Application for a non-material amendment following a grant of planning permission.  
 Town and Country Planning Act 1990

PROPOSED SINGLE STOREY EXTENSION TO LEAK  
CREATING NEW UTILITY ROOM

21/04330/01

WINDOW @ SIDE OF UTILITY ADJUSTED IN POSITION &  
SIZE AS BUILT ON SITE.

Proposed Side Elevation

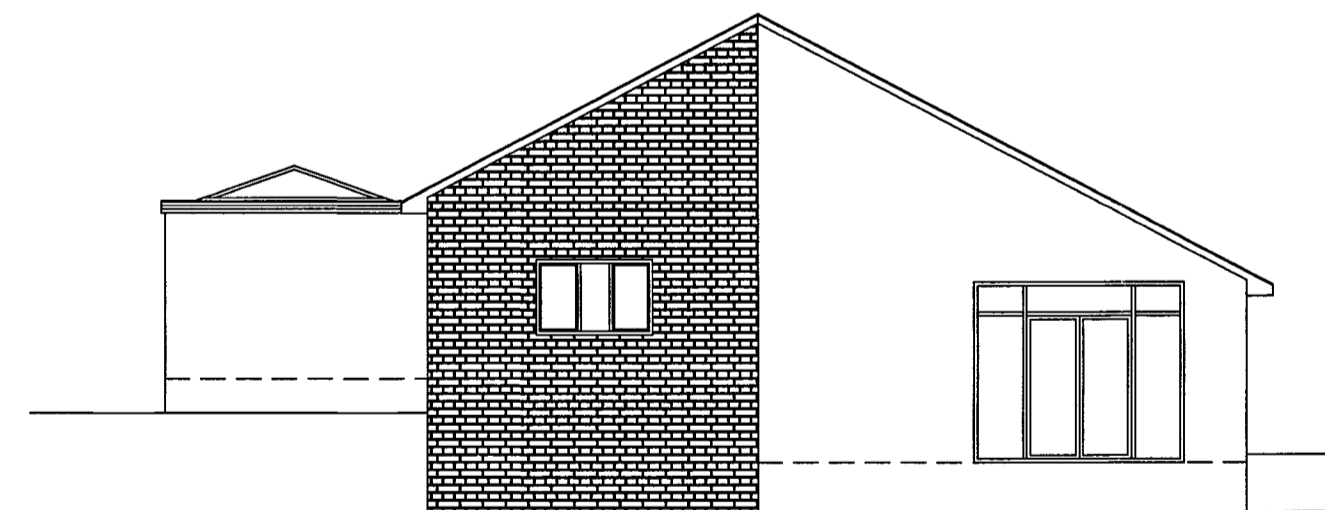
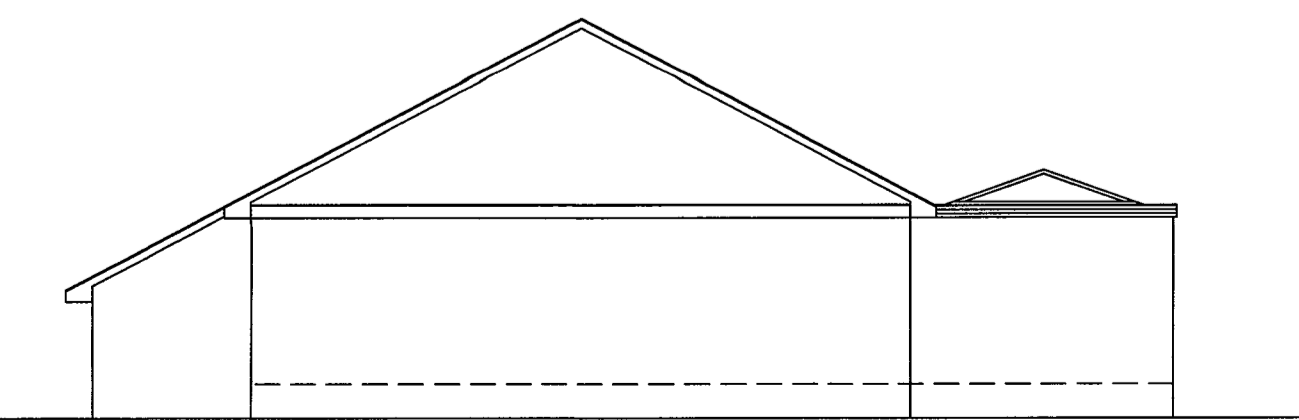
• WINDOW POSITION & SIZE ALTERED.
